RE: Nowak Short Plat (SP-10-00009)

The Kittitas County Community Development Services Department has determined that the Nowak Short Plat (SP-10-00009) is a complete application and hereby grants *conditional preliminary approval* subject to the following conditions:

*NOWAK*  
**ALEXANDER SHORT PLAT**  
WITHIN THE SW 1/4 SECTION 3 T18N R18EW  
KITITAS COUNTY WA.

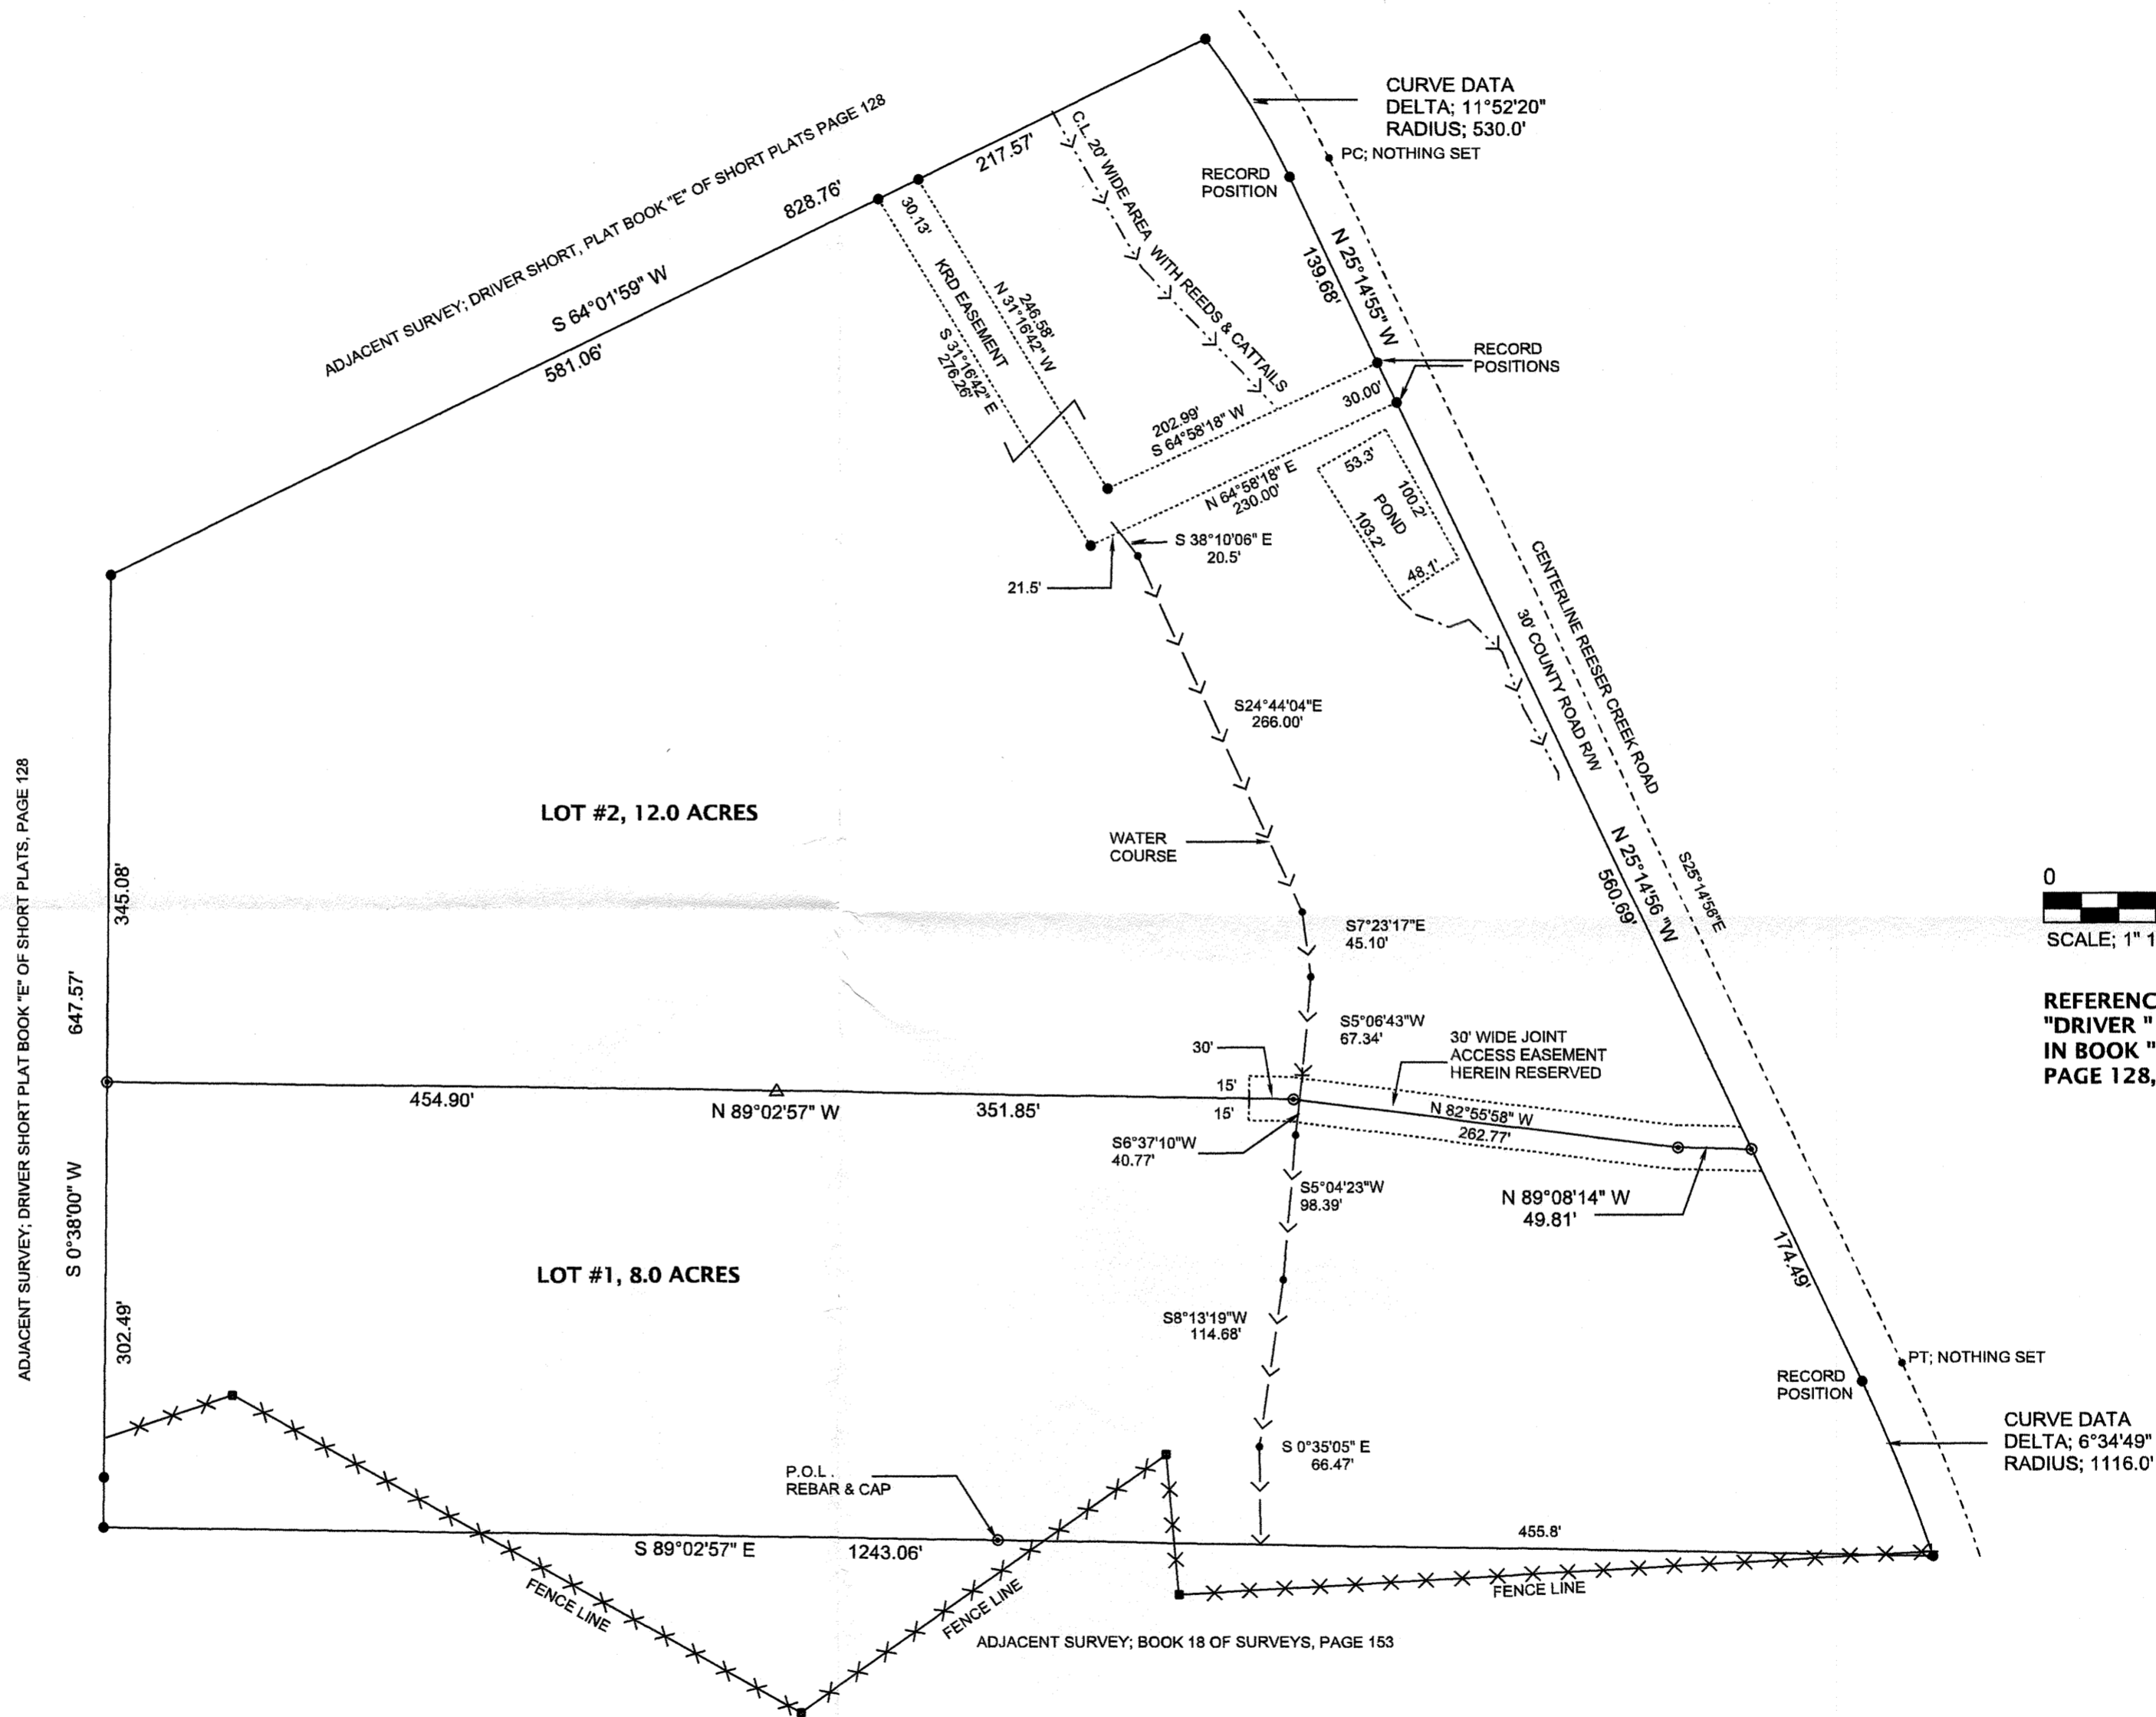
1. Both sheets of the final mylars shall reflect short plat number SP-10-00009 and an accurate legal description shall be shown on the face of the final plat.

11. Both lots of the Nowak Short Plat have a PEMA wetland across the east end of the property. The Final mylars shall reflect the location of this wetland and a statement on the plat shall read as follows: "Future development of lots may require a study by a certified wetland biologist to determine wetland classification and for buffer requirements pursuant to KCC Critical Areas Code."

16. "Reecer Creek Road" is incorrectly spelled on the Preliminary Plat.
17. Please review KCC 16.12 (at http://www.co.kittitas.wa.us/boc/countycode/title16.asp#Chapter_16.12) to insure that all plat drawing requirements met.
